CITY OF ALBUQUERQUE

August 14, 2014

**Re: Silver Moon Apartments
10th St & Park Ave.
Request Permanent C.O. – Not Accepted
Engineer's Stamp dated: 5-1-13 (K13D072)
Certification dated: 8-12-14**

DRAWN BY
REVIEWED BY
DATE 5.8.2013
PROJECT NO. 17-1013-01
DRAWING NAME
**SILVER MOON LODGE
GRADING AND
DRAINAGE PLAN**

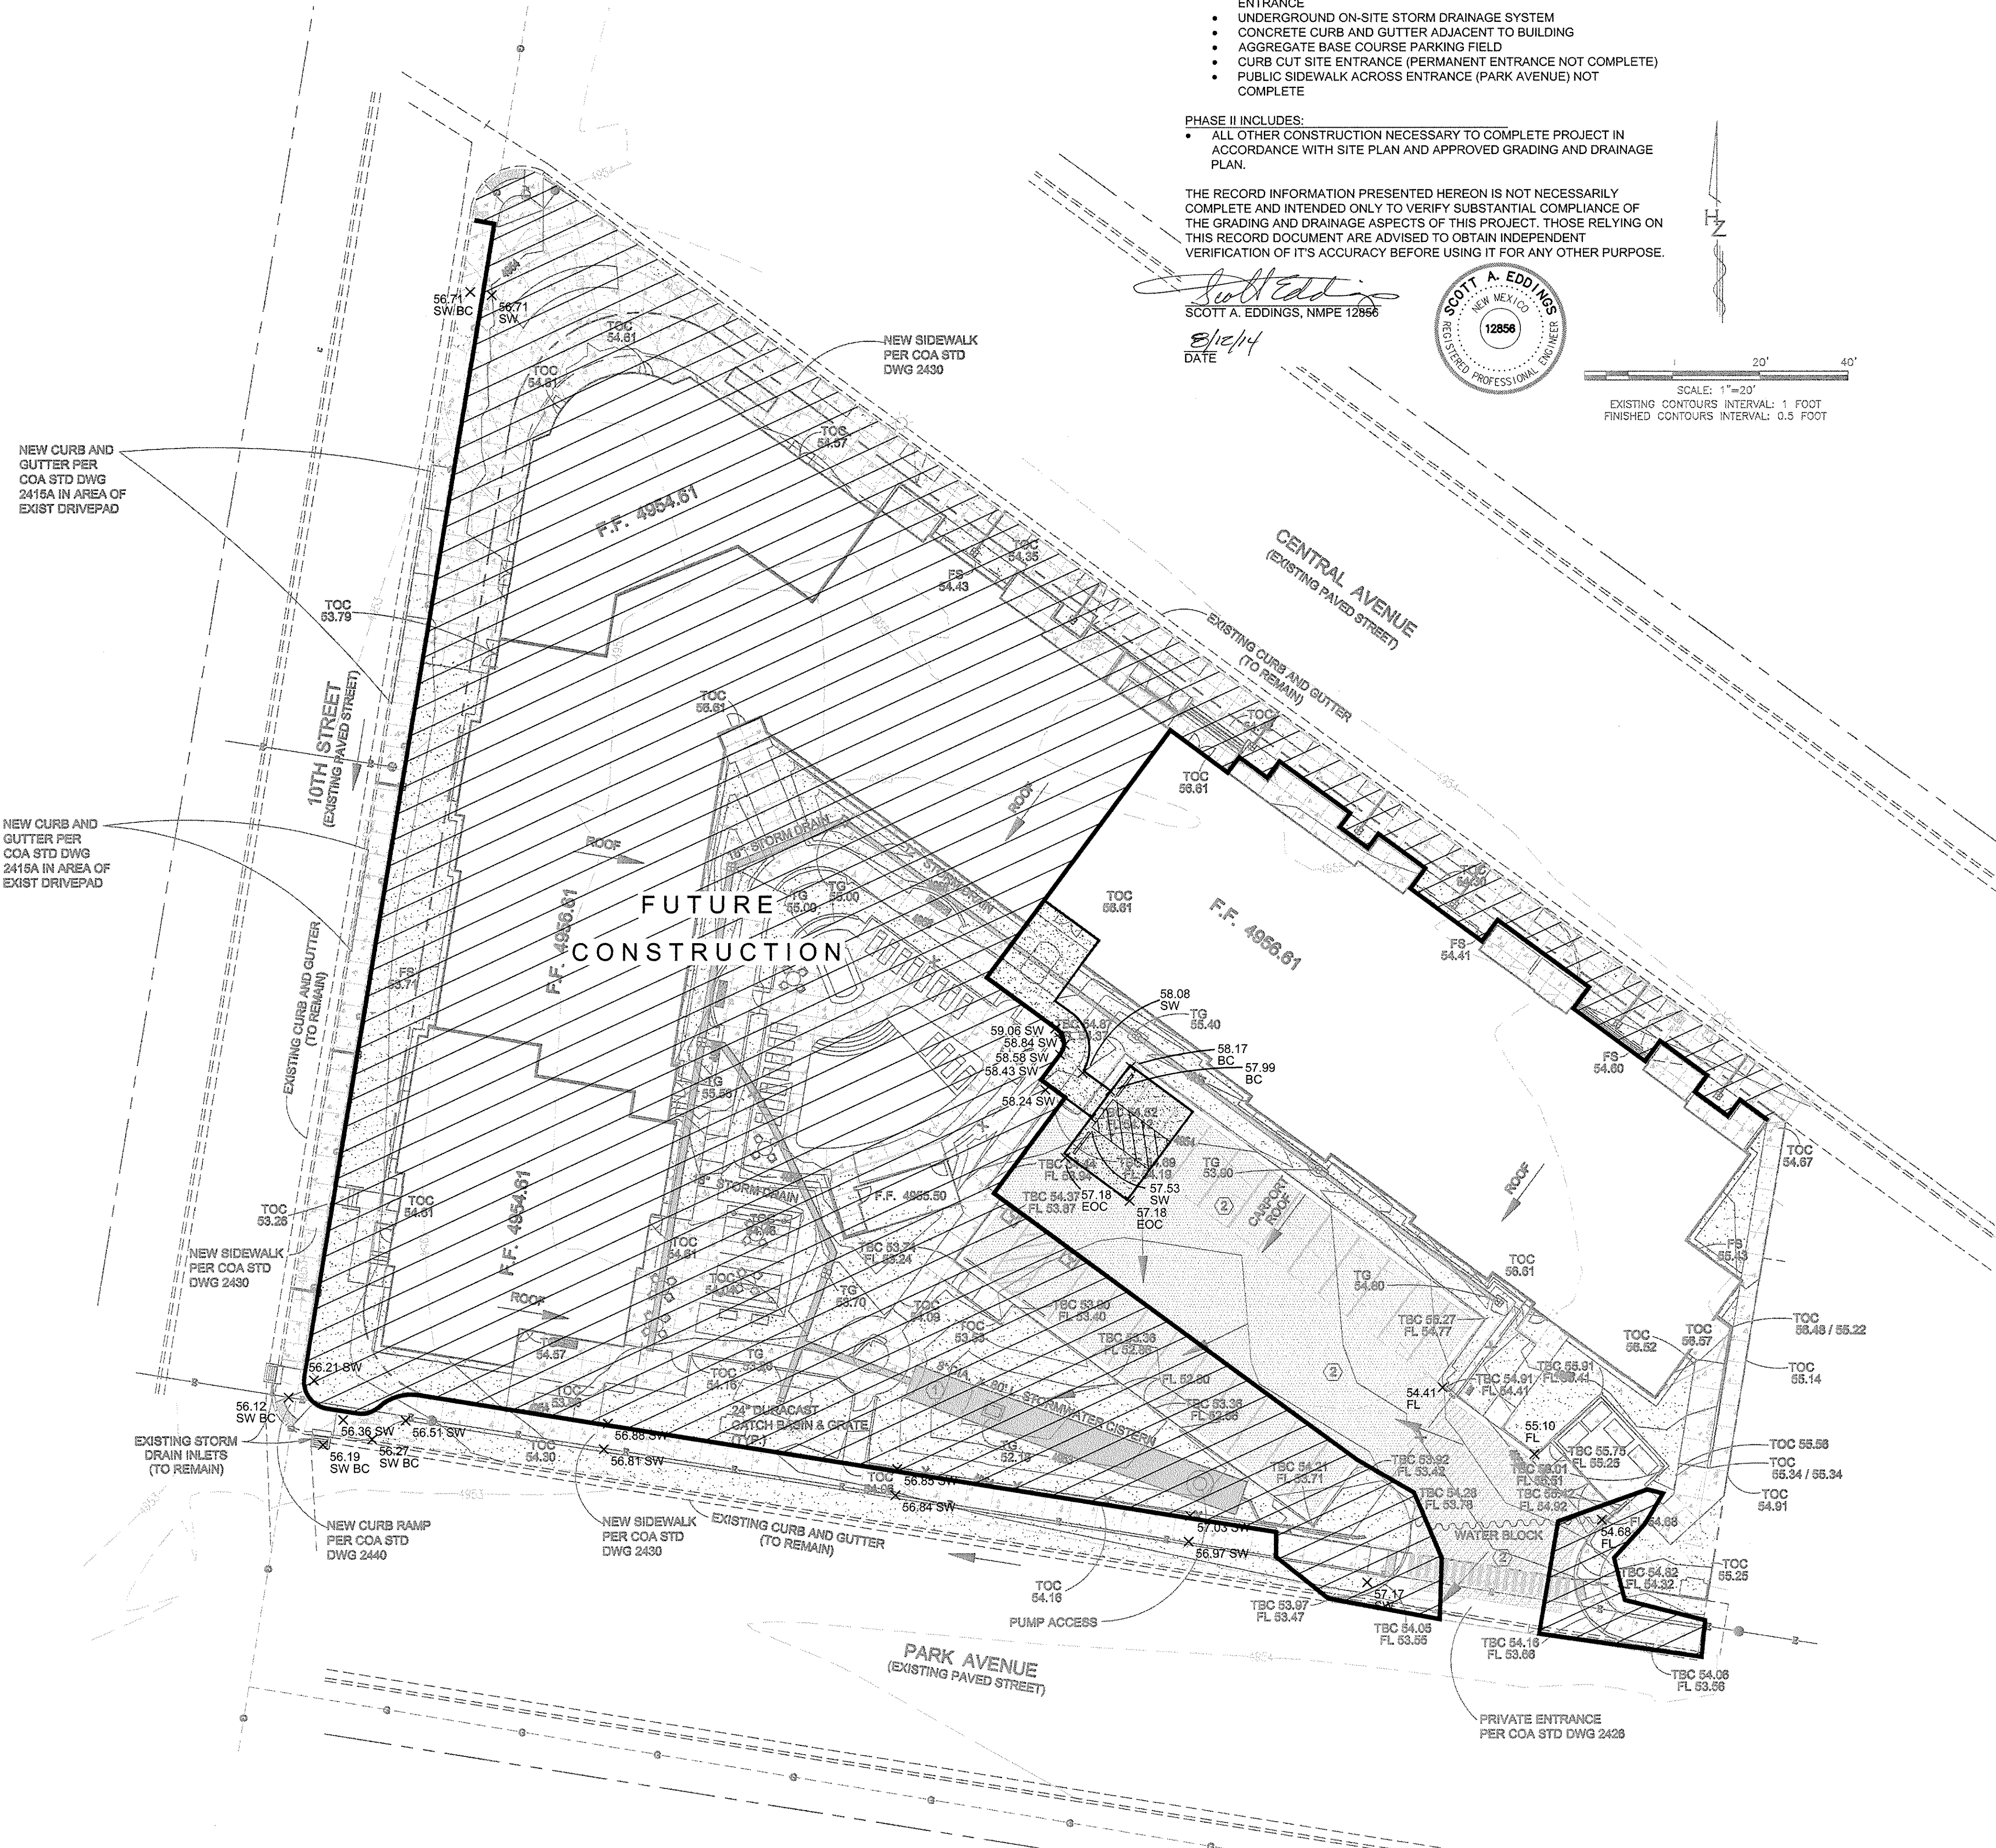
- The plan submitted for CO does not match the approved Grading and Drainage plan.
- We cannot give a partial CO, when the entire site was submitted under one building permit and not in phases.
- The site does not drain in substantial compliance.
- The drainage certification language does not match the hatched areas given on the plan.
- The site is a concern for the safety of its patrons.
